Fire Safety Engineering Design Review for DA Submission

327-335 Burley Road, Horsley Park
NSW (Lot 202, formerly Lot 204)

Date: 26 August 2021
Document ref: 274221.2102
Issue No: 2.0
Author: Parkan Behayeddin

1 Site Facilities Plan - (Lot 202)
202-A200 1: 500 @B1

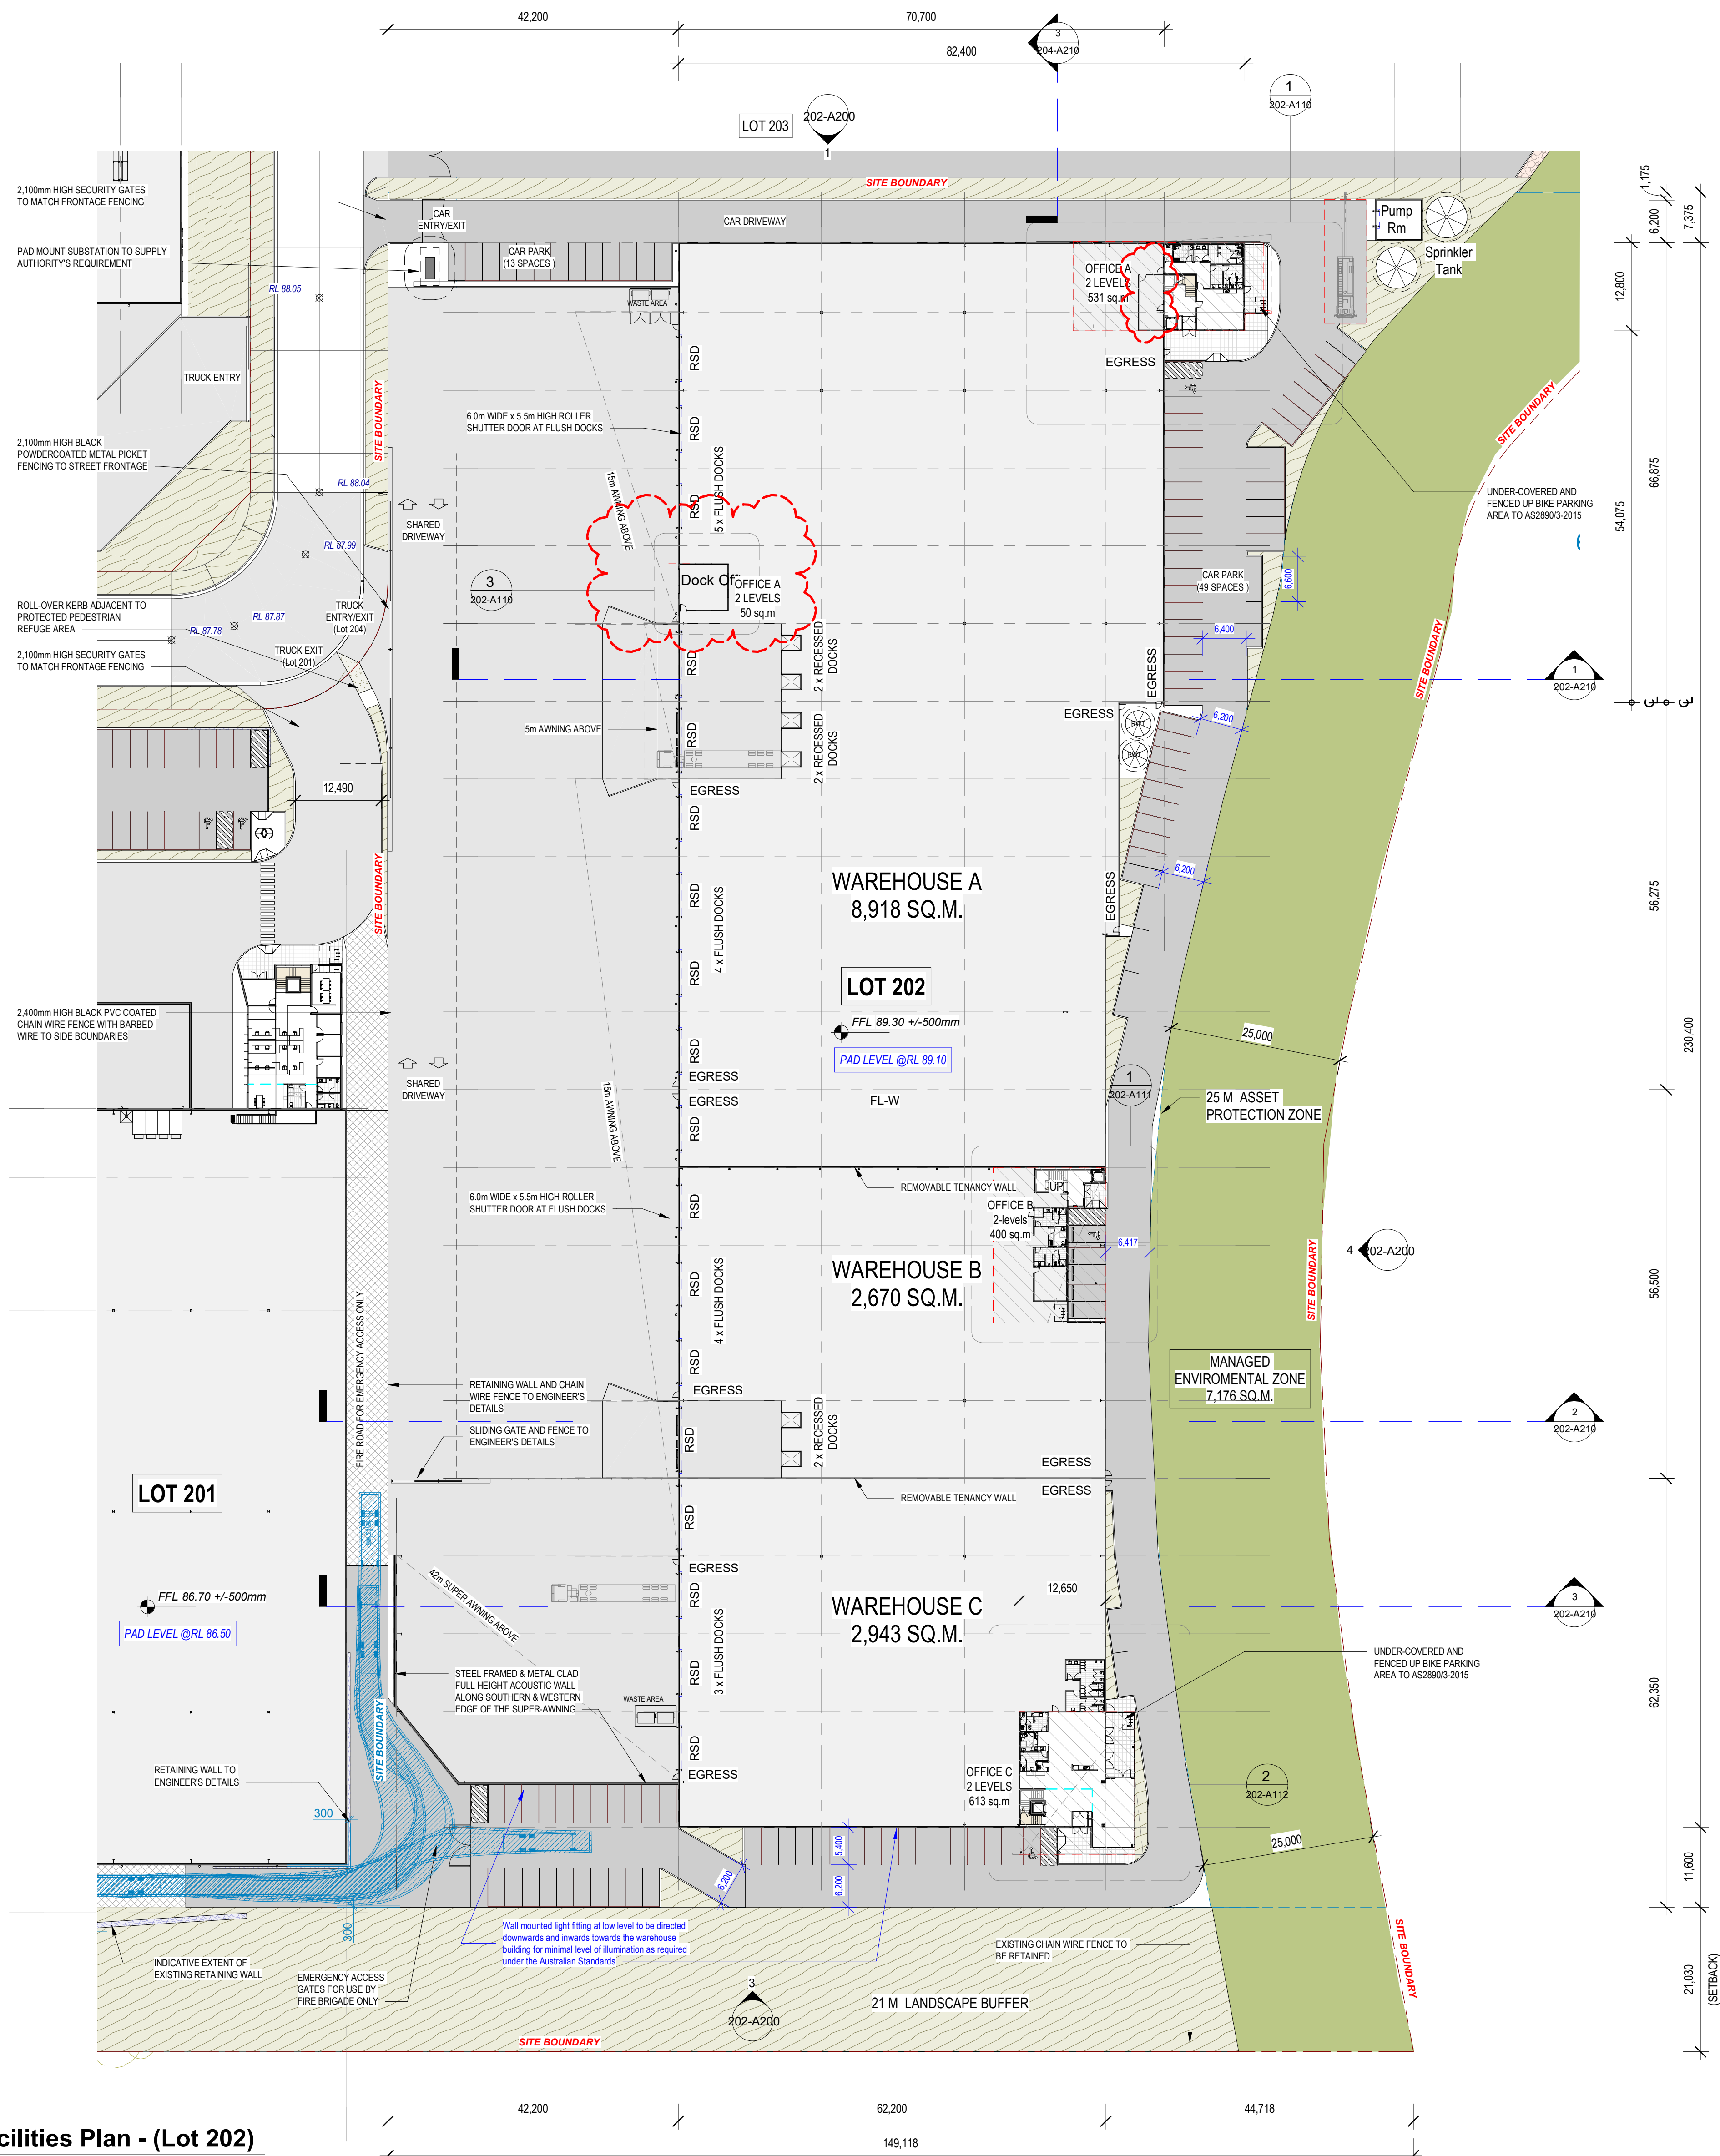
In the context of occupant egress for all warehouse portions, egress distances (and the distance between alternative exits) have been identified to exceed the maximum prescribed distances. More specifically, exit travel distances to an exit (where 2 exits in separate directions is available) is measured to exceed 40m whilst the distance between alternative exits exceeds 60m. In order to reduce the impact of the identified egress related design issues, measures including a post incident mechanical smoke clearance system, the reliance on the large volume within the warehouses and the presence of storage sprinklers (initiating a building wide alarm) will assist in controlling and/or suppressing a potential fire and provide safe conditions during occupant egress and fire brigade intervention. With respect to the office portions, it has been identified that the egress travel distances to a single exit (on the first floor levels) exceeds the maximum distance of 20m. To compensate for the extended travel distances within the office portions, a smoke detection and alarm system shall be proposed throughout the office portions. This has been detailed in Section 4.2.

Preliminary review of the project information highlights a number of egress related design issues which include the distance of travel within the warehouse/processing portions exceeding the maximum prescribed distances of 40m and the distance between alternative exits exceeding 60m.

The preliminary review of the design has identified that the proposed location of the sprinkler booster assembly being at the rear of the site is technically not within site of the main entrance or located at the principal entry to the site. The methodology to be adopted to address the design issue relative to the location of the sprinkler booster assembly shall be based upon a qualitative evaluation. The evaluation shall give consideration to the potential risks associated with the proposed sprinkler booster assembly location and the proposed fire safety measures which shall assist attending Fire Brigade personnel in locating the respective booster assemblies. The identified measures shall include block plans, additional signage denoting the sprinkler booster location on site, the adoption of a red strobe light to clear denote to attending fire brigade personnel the location of the sprinkler booster and also to ensure that the booster is accessible to accommodate fire brigade operations. The preliminary assessment undertaken by Scientific Fire Services suggests that the identified design issue for the sprinkler booster can satisfy the relevant *Performance Requirements*, namely EP1.4 of the BCA.

Design Issue to be Addressed	NCC DtS Provision	Performance Requirement
<p>It has been identified that the super awnings located along the western portion of the building form part of the external wall and are located within close proximity to the title boundary (within 3.0m) without the required fire rating pursuant to Type C fire resisting construction.</p> <p>It should be noted that the super awnings contain openings that are located within 3.0m from the title boundary.</p>	<p>Clause C1.1 inter alia Specification C1.1 &</p> <p>Clause C3.2 inter alia Clause C3.4</p>	CP1 & CP2
<p>The following design issues have been identified with respect to the proposed perimeter vehicular access serving the building:</p> <ul style="list-style-type: none"> The perimeter vehicular access is located more than 18m away from the external wall of the building (Warehouse A, B, and C) due to the recess docks (i.e. up to 45m); and Any perimeter fence gates (and gates forming part of the vehicular access) that are proposed to be locked are required to be fitted with suitable conventional padlocks to enable fire-fighter access with a standard key (i.e. 003 key locks). Alternatively, non-conventional padlocks are permitted provided access keys are provided to Fire & Rescue New South Wales (FRNSW) responding fire station stations. <p>Note: External hardstand fencing is not proposed with the Modification 3 submission.</p>	<p>Clause C2.3 inter alia Clause C2.4</p>	CP9
